WEST SUSSEX COUNTY COUNCIL CONSULTATION

TO:	Arun District Council FAO:Mr A Wood
FROM:	WSCC - Highways Authority
DATE:	16 June 2021
LOCATION:	66 The Street Littlehampton BN16 3NR
SUBJECT:	R/113/21/PL Construction of a single-storey upwards extension to provide an additional 4 No. residential units. This application affects the setting of a listed building & affects the character & appearance of the Rustington Conservation Area & is in CIL Zone 4 (Zero Rated) as flats.
DATE OF SITE VISIT:	n/a
RECOMMENDATION:	Advice
S106 CONTRIBUTION TOTAL:	n/a

GROUND FLOOR PLAN

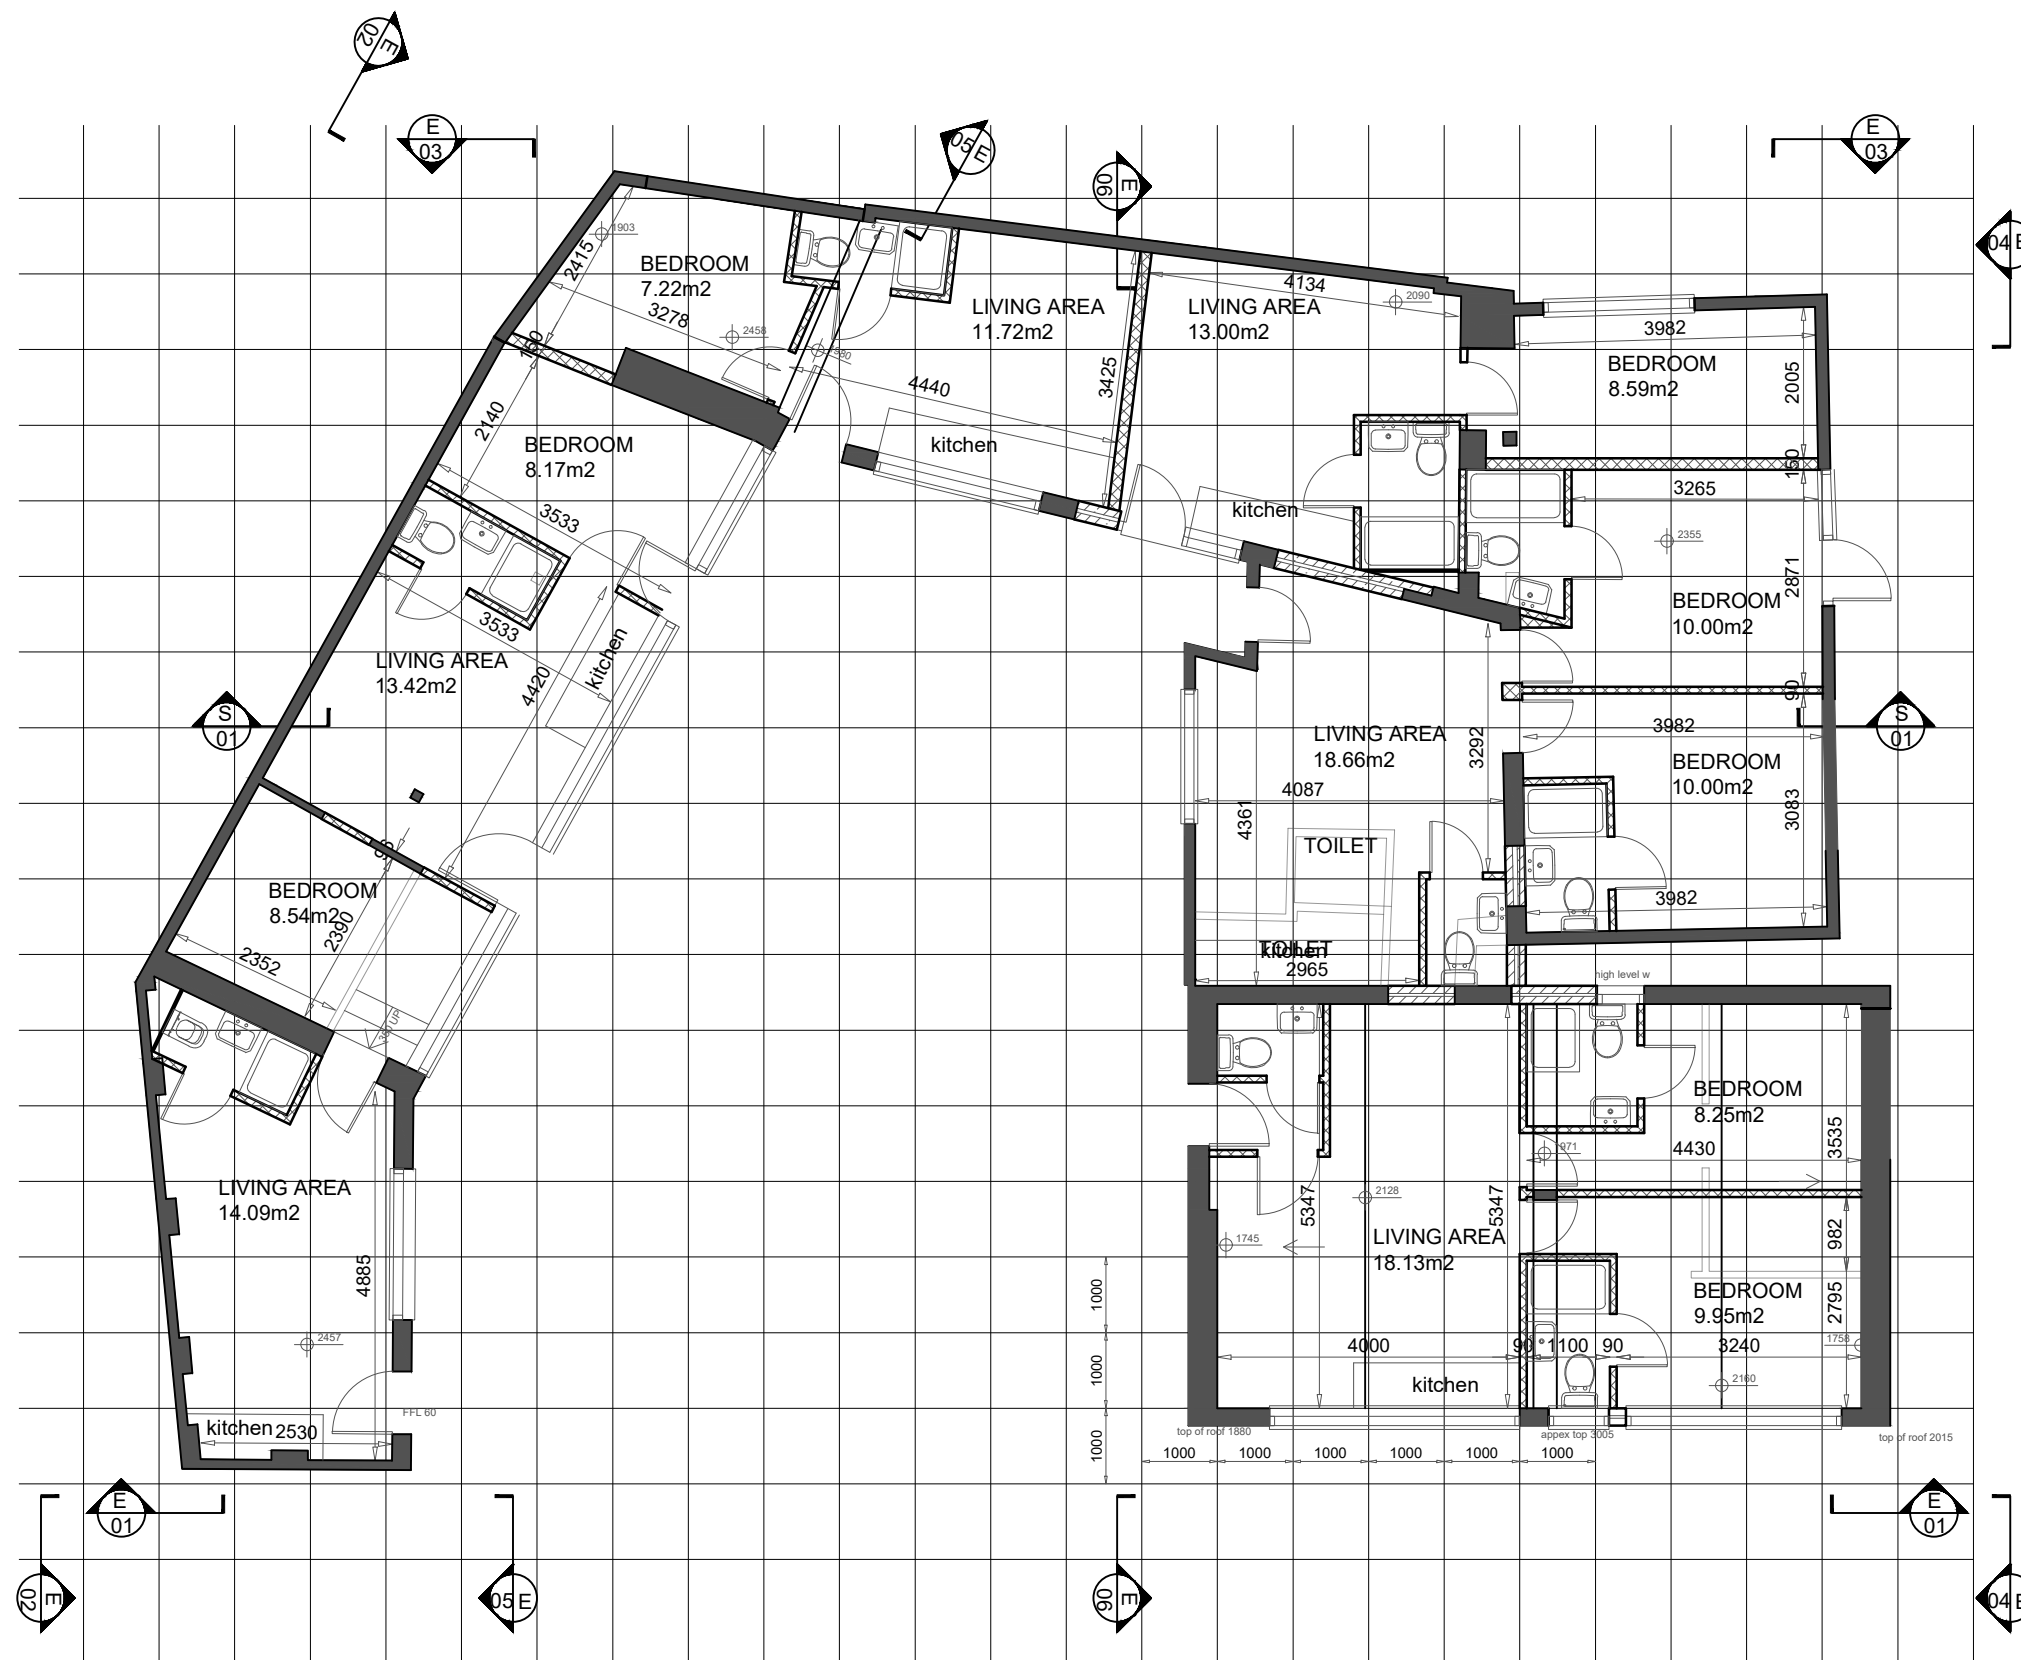
No additional parking is proposed to serve the proposed extension. The site layout plan demonstrates existing onsite parking provision of 6 parking spaces. However, these are tandem parked and for independent residential use would result in vehicle users blocking each other. Given this, the site would realistically be able to accommodate 3 vehicles.

Based on Arun parking standards, the permitted use would create a demand of 7 parking spaces (1 parking space for each flat + a visitor provision totalling 20% of total the number of dwellings). Given that the existing parking can accommodate 3 vehicles, the potential shortfall would be 4 spaces. However, the LHA is mindful that this application is already permitted and not part of the current proposal.
